Our Ref: BE/28/20/NMA

Non material amendment following the grant of BE/135/18/PL for the minor design change to supermarket by changing cladding to a 'Duraclad' Composite Timber Cladding.

Land At Salt Box West Of Shripney Road Bognor Regis PO22 9NW

EAST ELEVATION

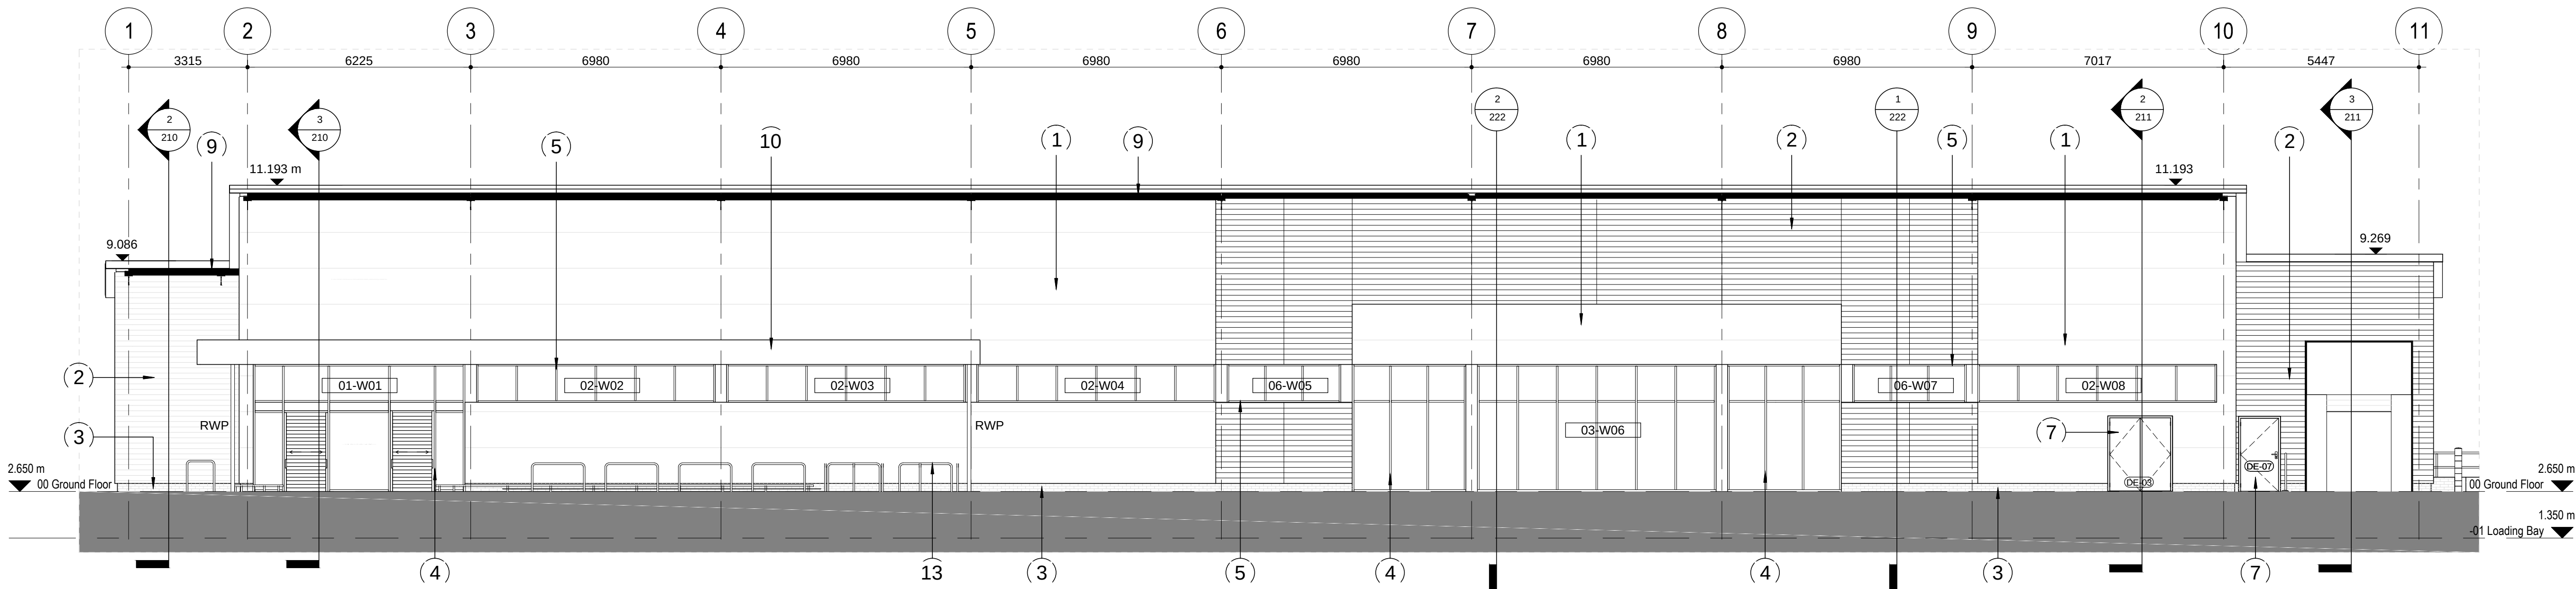
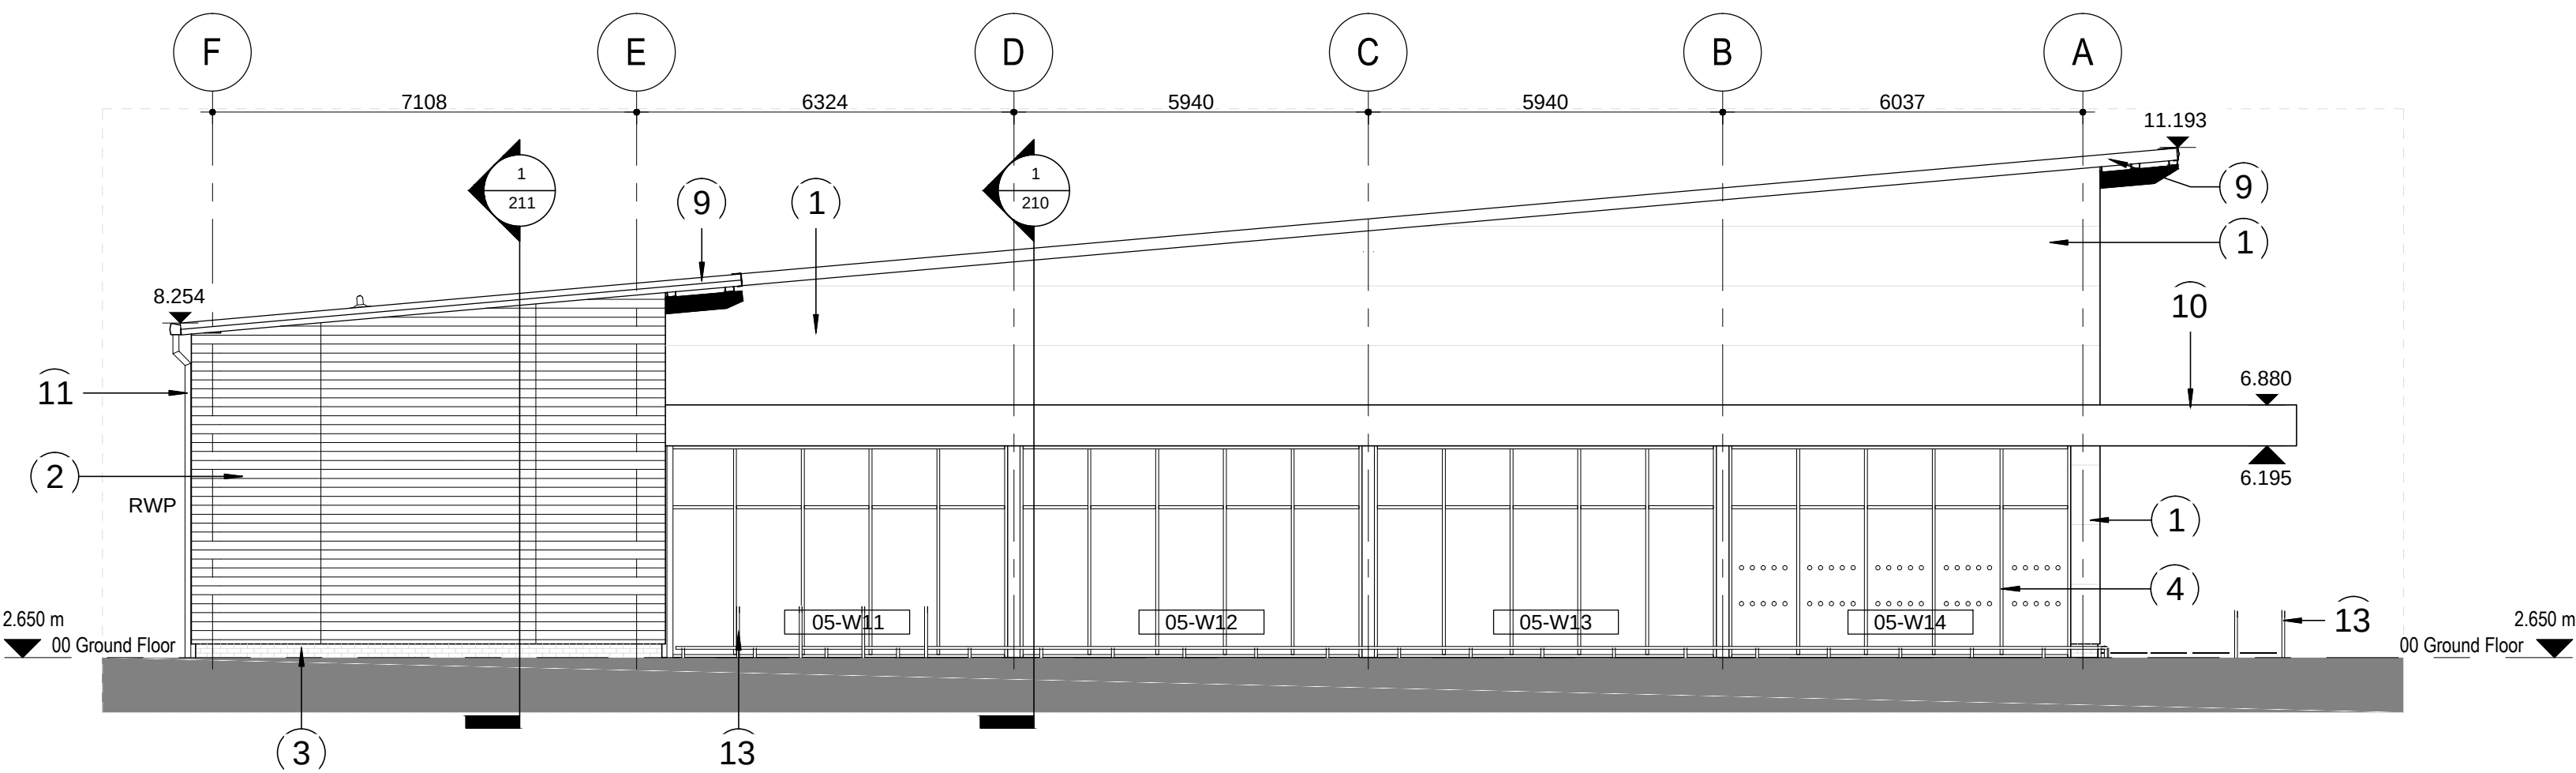
Notwithstanding this, the reason that this proposed Non-Material Amendment is REFUSED by the Local Planning Authority is that the proposed 'Duraclad' Composite Timber Cladding is not identical in visual terms to the approved cladding for Units 4, 5 and 8 which comprises 'Accoya Timber Cladding (Light Oak)', as approved under Discharge of Condition application BE/15/20/DOC on 20th March 2020.

cladding which has also been approved on the two drive-thru buildings (Units 4 and 5). It is considered that the use of the 'Duraclad' Composite Timber Cladding on Unit 8 would be unacceptable in visual terms as it would not match the 'Accoya Timber Cladding (Light Oak)' approved for Units 4, 5 and 8; consequently the materials on the three units would not match. The 'Accoya Timber Cladding (Light Oak)' was approved under the discharge of condition application BE/15/20/DOC for its high quality appearance and durability.
